From: Amanda Scholes on behalf of Planning.Responses
Sent: 02 December 2020 10:48
To: Planning Scanning
Subject: FW: Reserved matters application A/109/20/RES – Land South of Water Lane, Angmering.

Please upload onto Ocella the email below which is a consultation response from the **ADC Drainage Engineers** withdrawing their holding objection to reserved matters application **A/109/20/RES** relating to Land South of Water Lane, Angmering.

Subject: Re: Reserved matters application A/109/20/RES – Land South of Water Lane, Angmering.

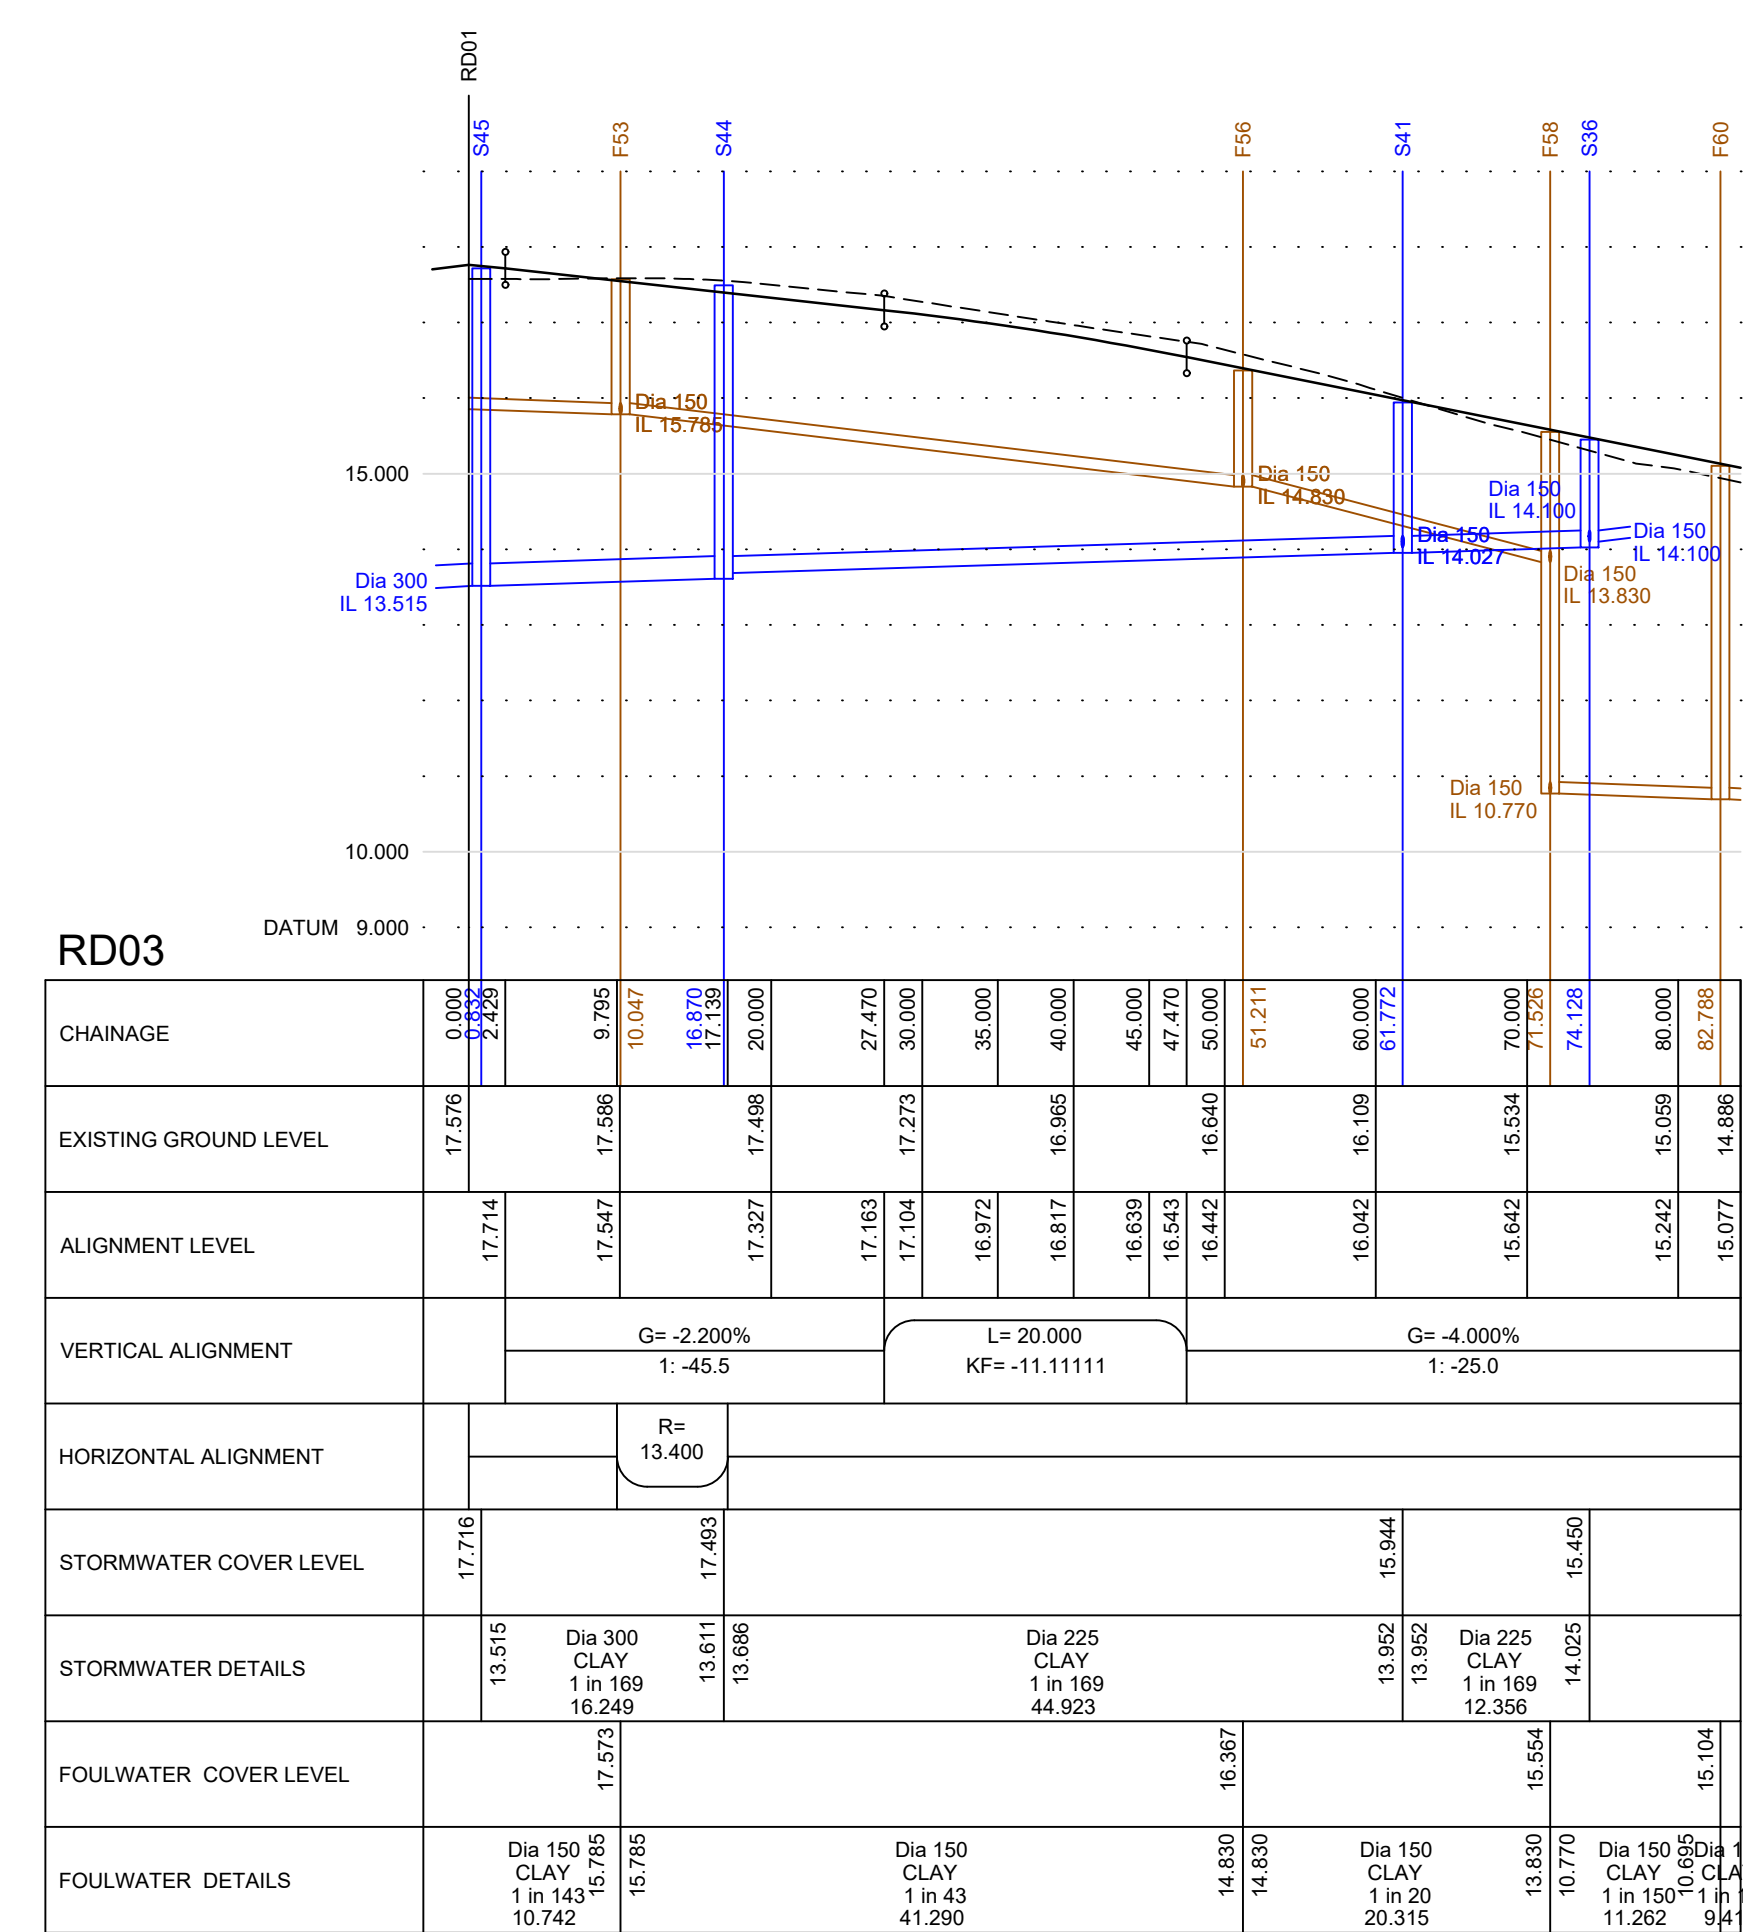
5. We still are not satisfied that water will not flood off site or flood proposed dwellings. Large flood volumes are observed within results. S1.007, with upstream manhole of S25 shows water levels of 13.687, which is greater than the cover and gully level. There are two manholes in the northern network with reference S25, and a layout with pipe numbers has not been provided, making review more difficult and time consuming than it should be. Highway gradients indicate that the access falls to water lane. Without an mdx file and better layout drawings which show cover levels, invert levels, surface levels and FFLs we have serious concerns about the degree of flooding predicted. Insufficient evidence has been submitted to allay these concerns. Please see below. Firstly we apologise as there is an obvious mistake in that the first S25 should be S23, to follow the obvious manhole numbering, which follows numerical sequence. However, as stated in the technical note "The cover level of S25 (upstream of 1.008) is 13.561m AOD with the gullies at 13.380m AOD. The water level in MH S25, in the 1 in 100 year storm event plus 40% climate change, is 13.214m. Therefore, even in this extreme storm event water does not spill from the gullies downstream of S25." There are also no "large" volumes of flood water on any of the northern print outs, even in the tested Urban Creep design which as stated is highly sensitivity tested, with the only flooding in that area being 0.106m³, basically a basin full. Please can we clarify. The drainage system should only be designed to cater for the 1:30 year storm with any storms in excess of this being allowed to flood and controlled within the site boundaries by either keeping it within highways, and/or directing it to greenspaces or ditches/watercourses. We have provided 1:100 year storm events with 40% climate change included with minimal flooding throughout the development even within the sensitivity tested overly designed Urban Creep scenario. The results show no flood risk to properties on or off site. *To confirm water from events exceeding the 1 in 30 year event must not exit your site without being attenuated, to allow spill into watercourses would increase flood risk off site. Policy requirements are clear that any exceedance water must be safely contained in site, the information you have provided to date has not demonstrated this. Some nodes in the site do show flooding in excess of 5m³ with some near to 15m³.*

Further to the below and Michael's email please find attached a further technical note following your comments. We have also included a link below to the amended drainage and areas drawings, and attached the full drainage print outs as well as an areas table.
